## 203 Fore Street Hotel - Preliminary Traffic Comments

Thu, Nov 30, 2017 at 10:39 AM

Hi Caitlin – I have reviewed the application materials and offer the following Preliminary Traffic Comments.

SITE PLAN LEVEL 01 - FORE STREET  
1/16" = 1'-0"

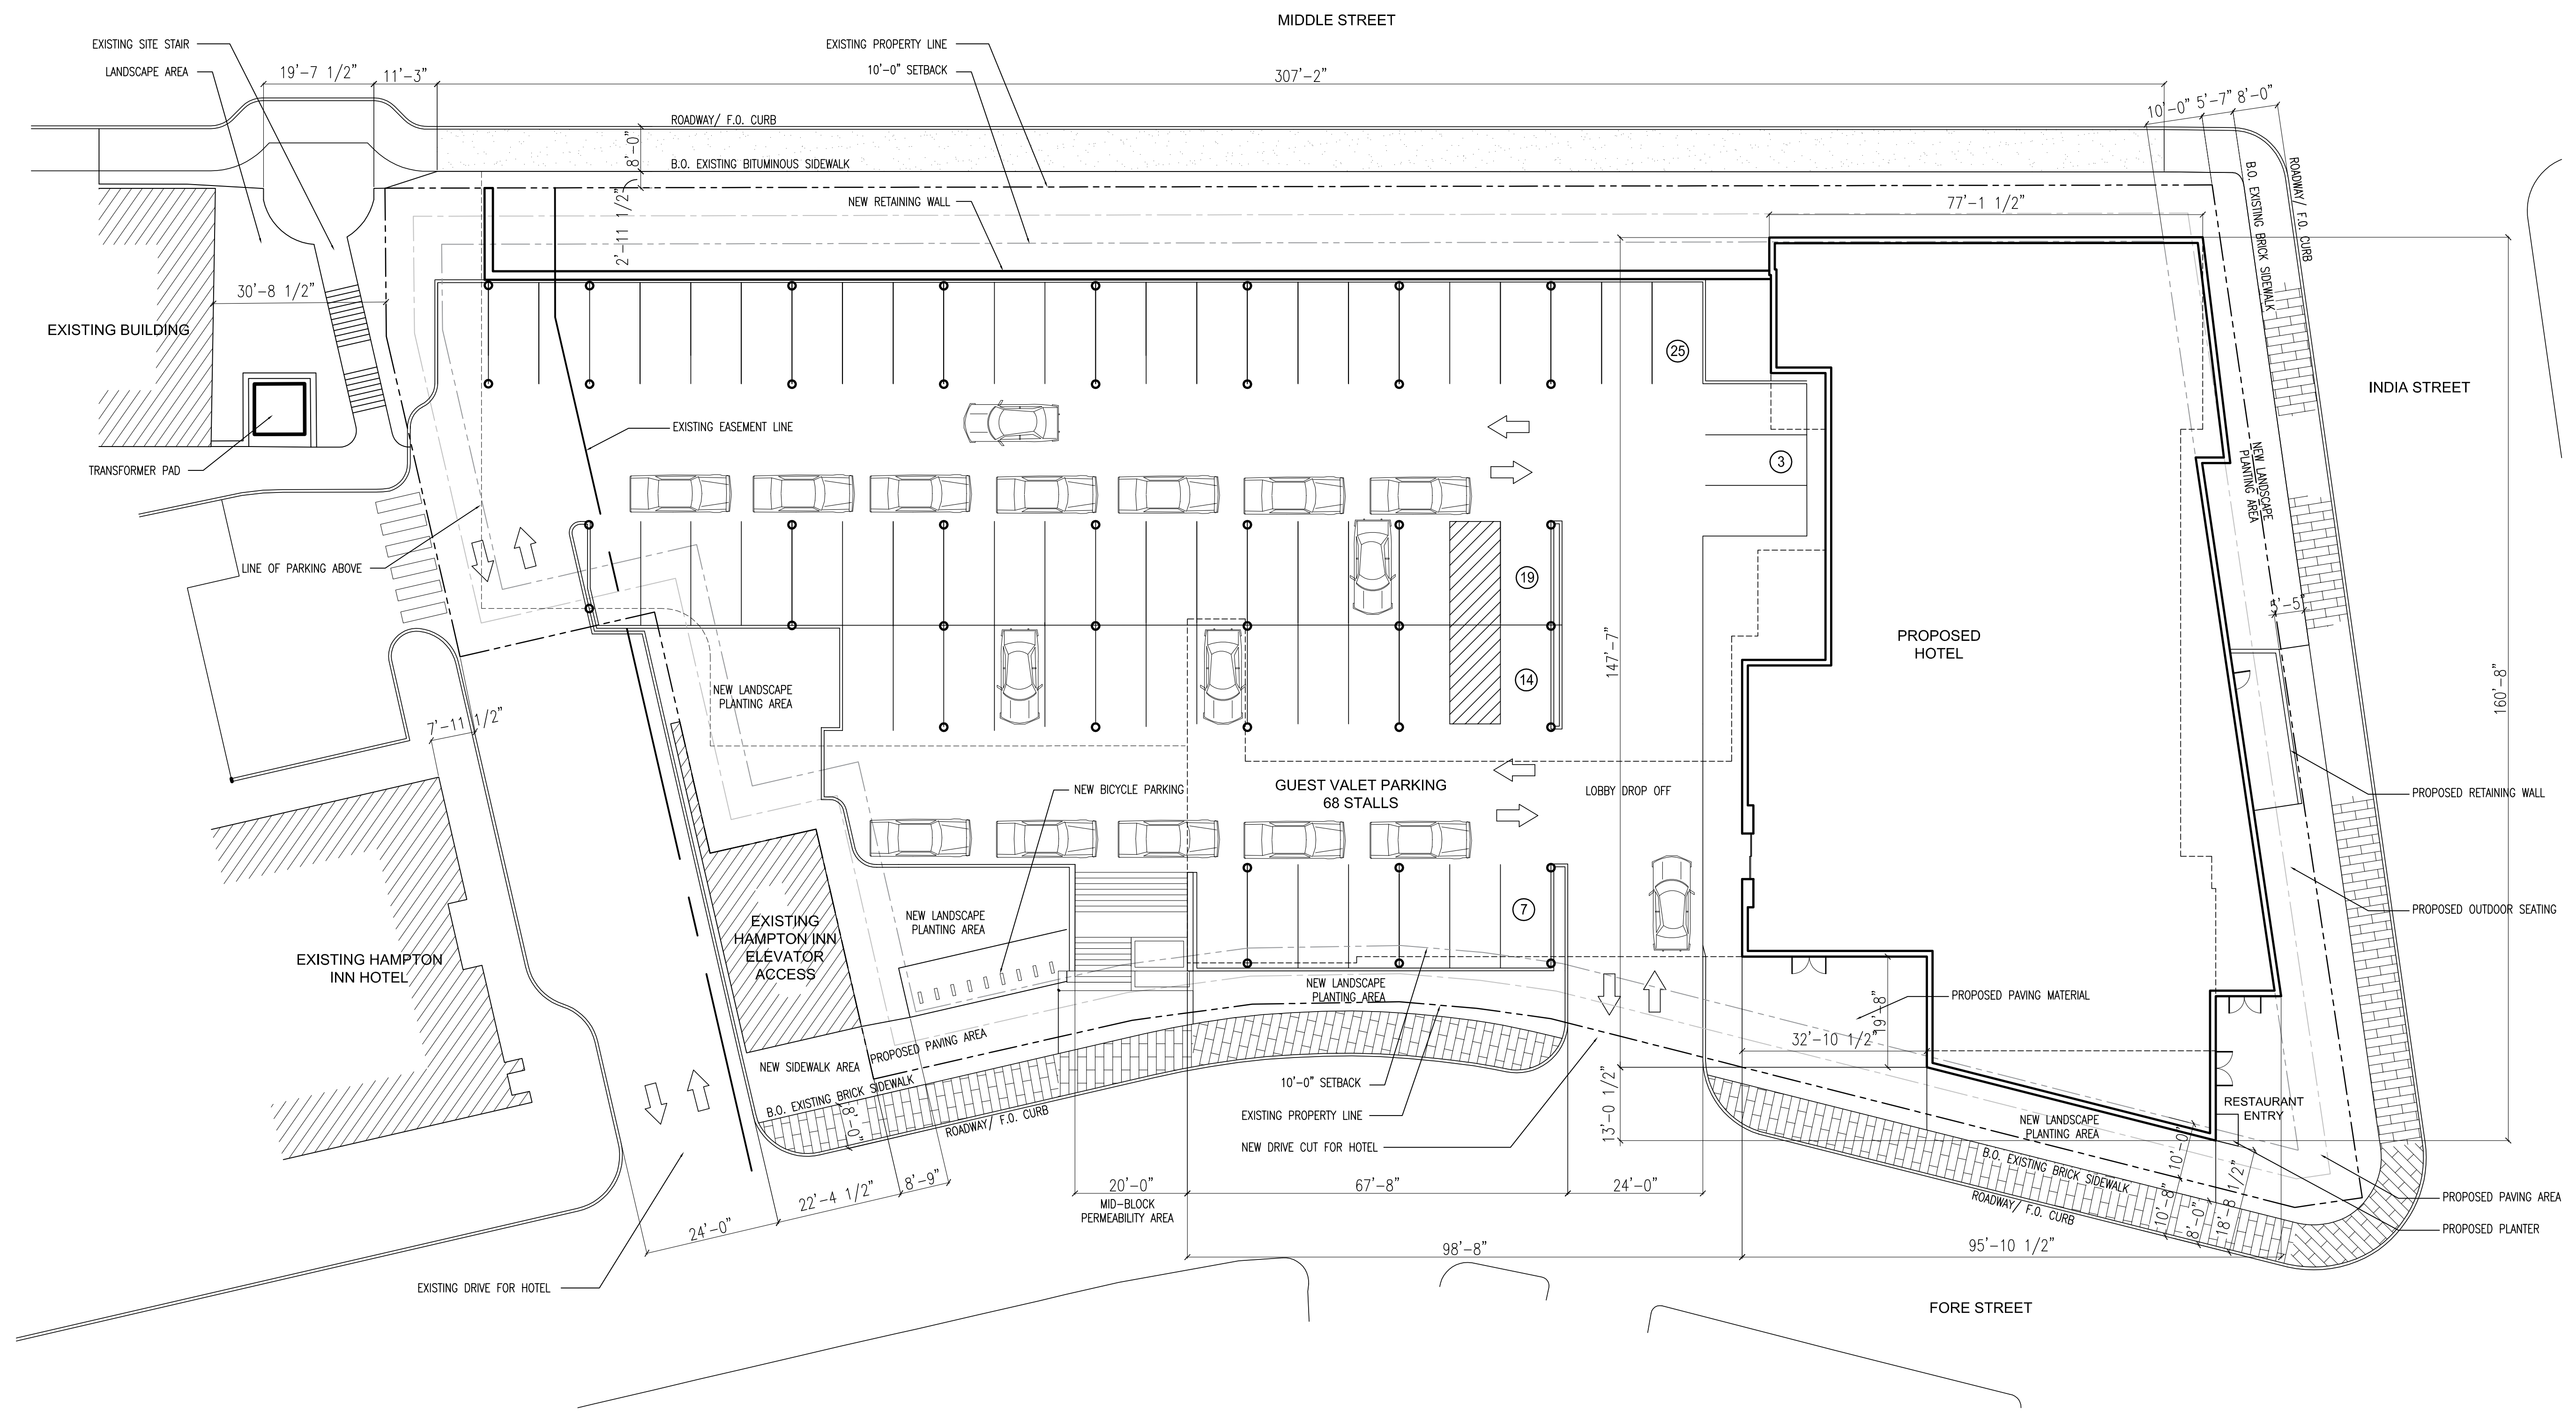
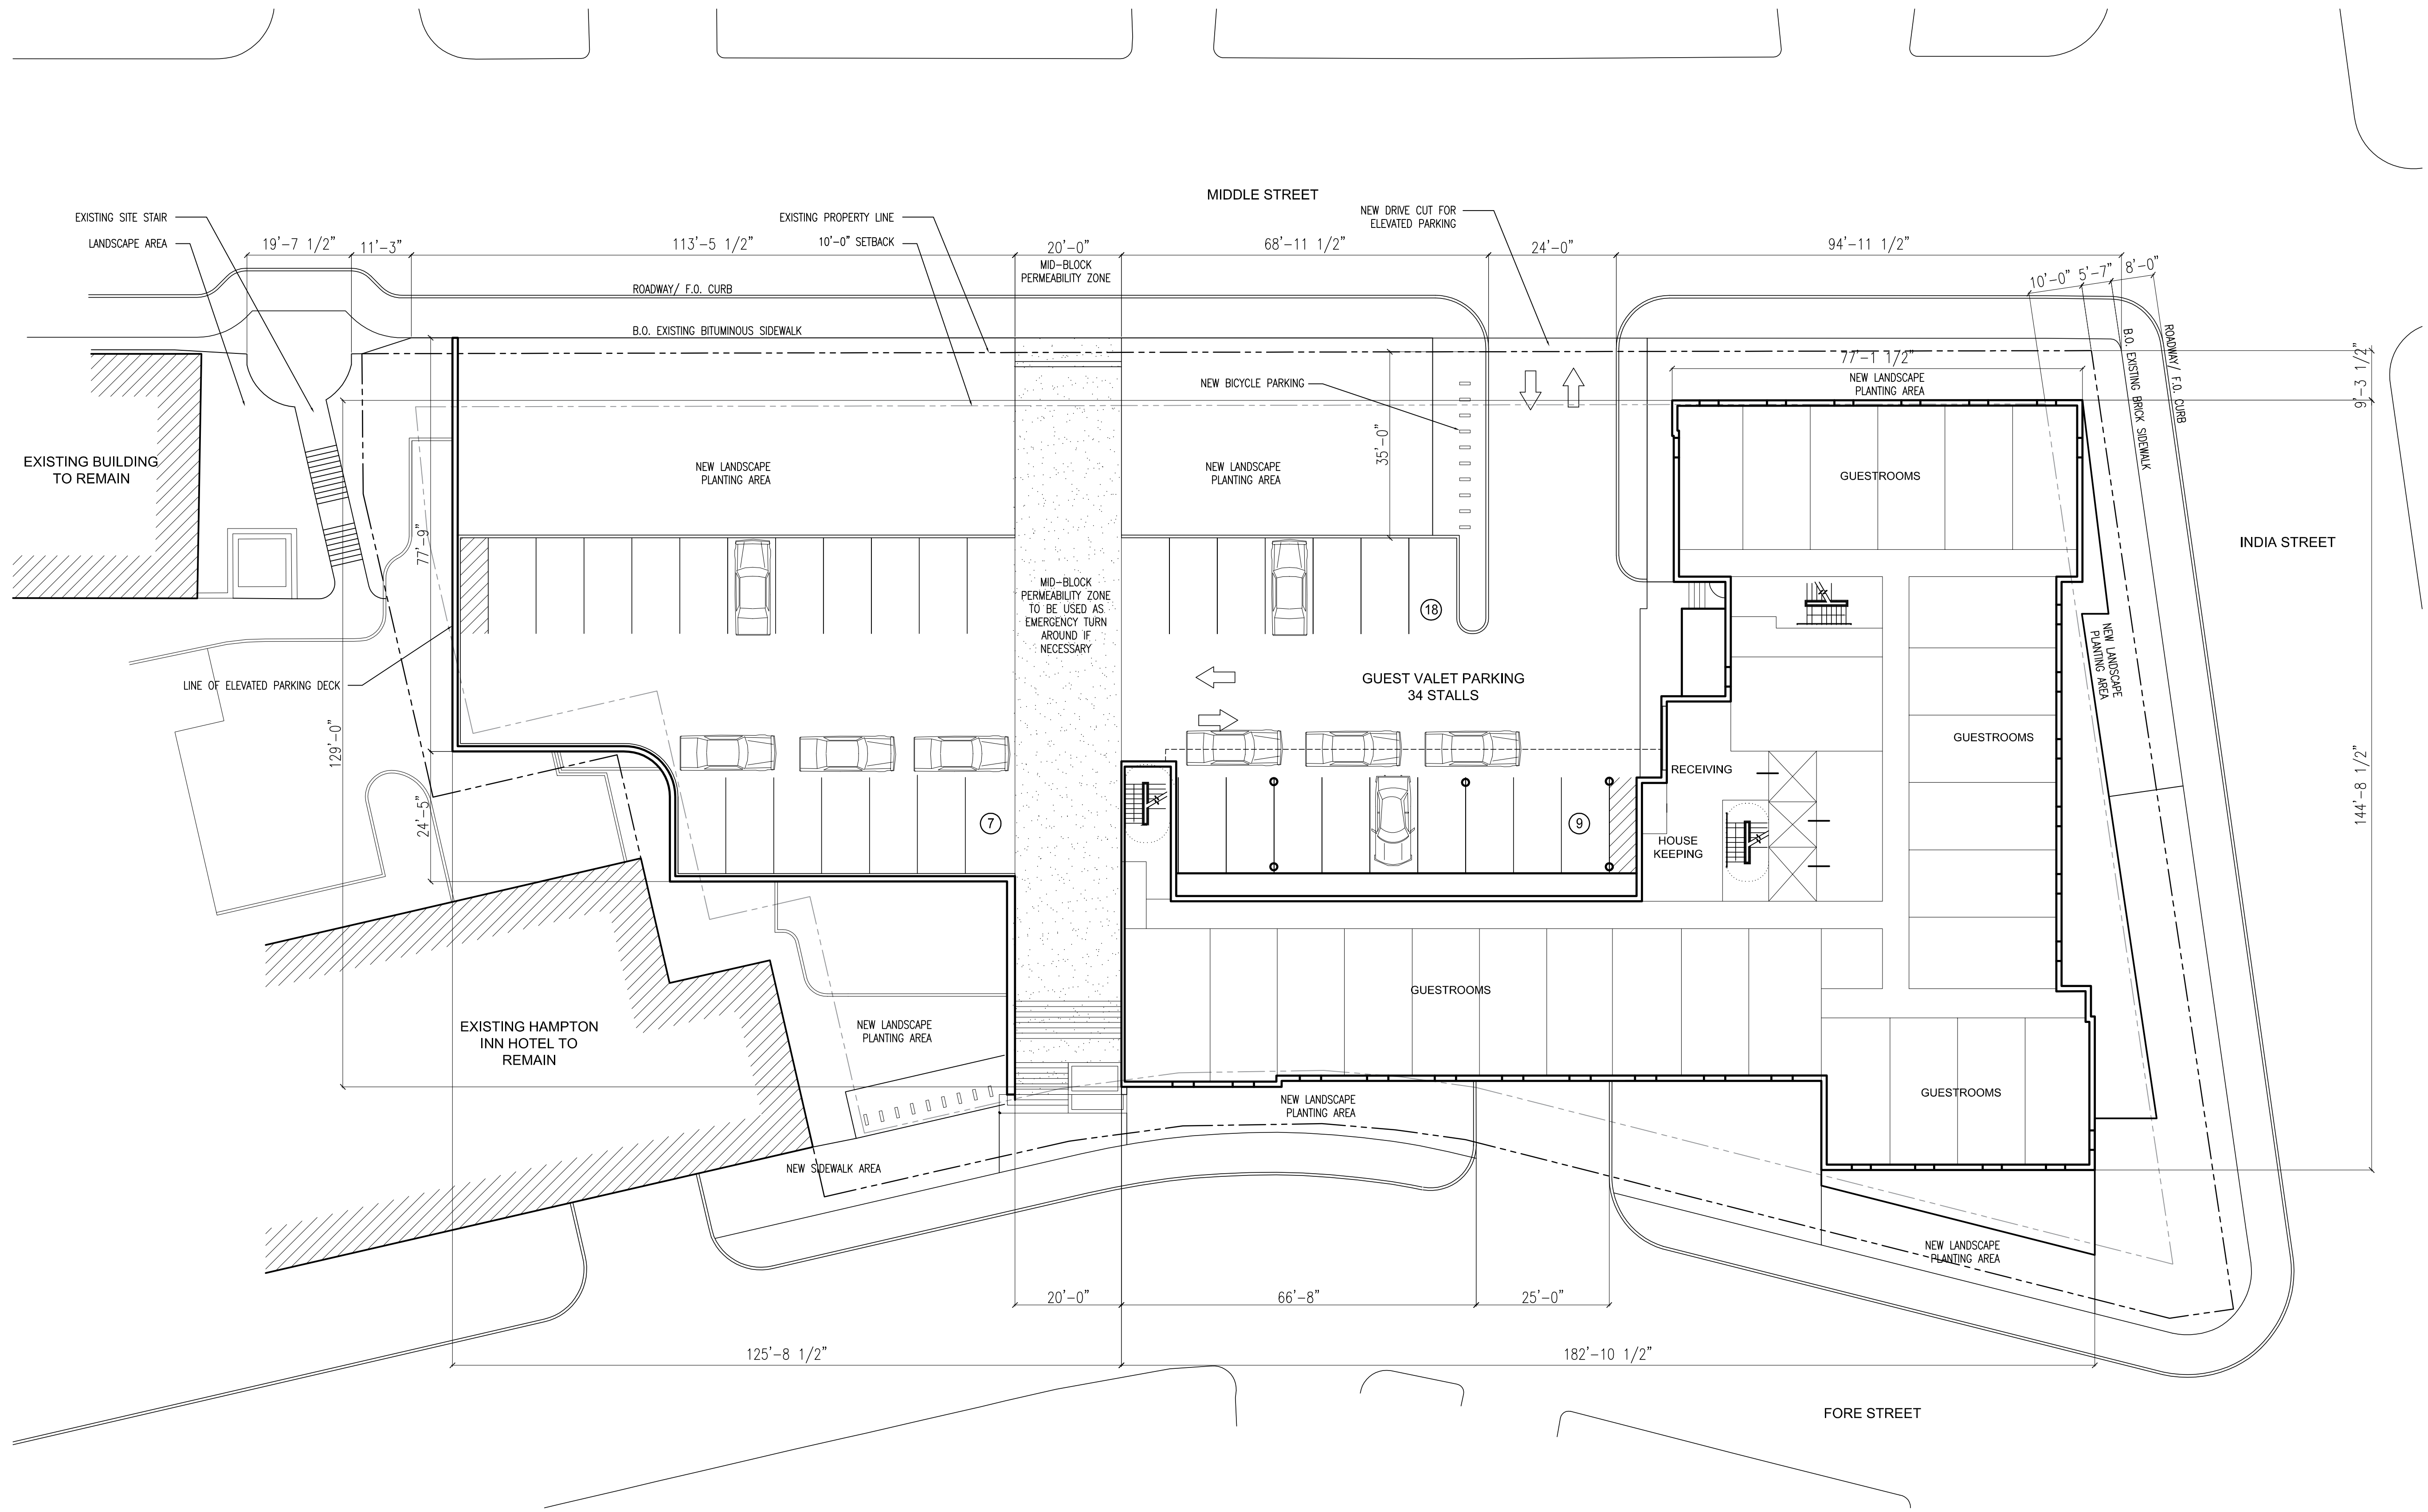
- The project is proposing two driveways (one on Middle Street and one on Fore Street). The number of driveways complies with City Technical standards (assuming the project is NOT a common scheme development. If the Hampton Inn Driveway is considered, the number of driveways exceeds City standards). I would note that the driveways will reduce the number of on-street parking spaces along both streets and thus consideration of narrowing driveway widths may be beneficial.

- I investigated the location of driveways as it relates to corner clearance standards (to India Street). Middle Street is classified as a Local Street and 35 feet of corner clearance is required. The proposed Middle Street driveway meets City standards. Fore Street is classified as a Collector Street and 150 of corner clearance is required. The proposed driveway appears to provide approximately 140 feet of separation and thus either the driveway will need to shift to the west or a waiver will need to be requested.

- The proposed driveway on Fore Street meets City driveway separation standards to the existing Hampton Inn driveway.

- The project will need to provide details on truck deliveries.
- The project will need to provide a parking demand/supply analysis and how parking will be managed between the proposed hotel and Hampton Inn. Also, details on valet parking management and vehicle circulation between to two parking areas shall be provided.
- I will provide comments on parking lot dimensions upon receipt of that information .
- It will be important that the mid-block walkway be designed to optimize pedestrian safety and minimize vehicle conflict.
- A construction management plan that complies with City requirements will be required.
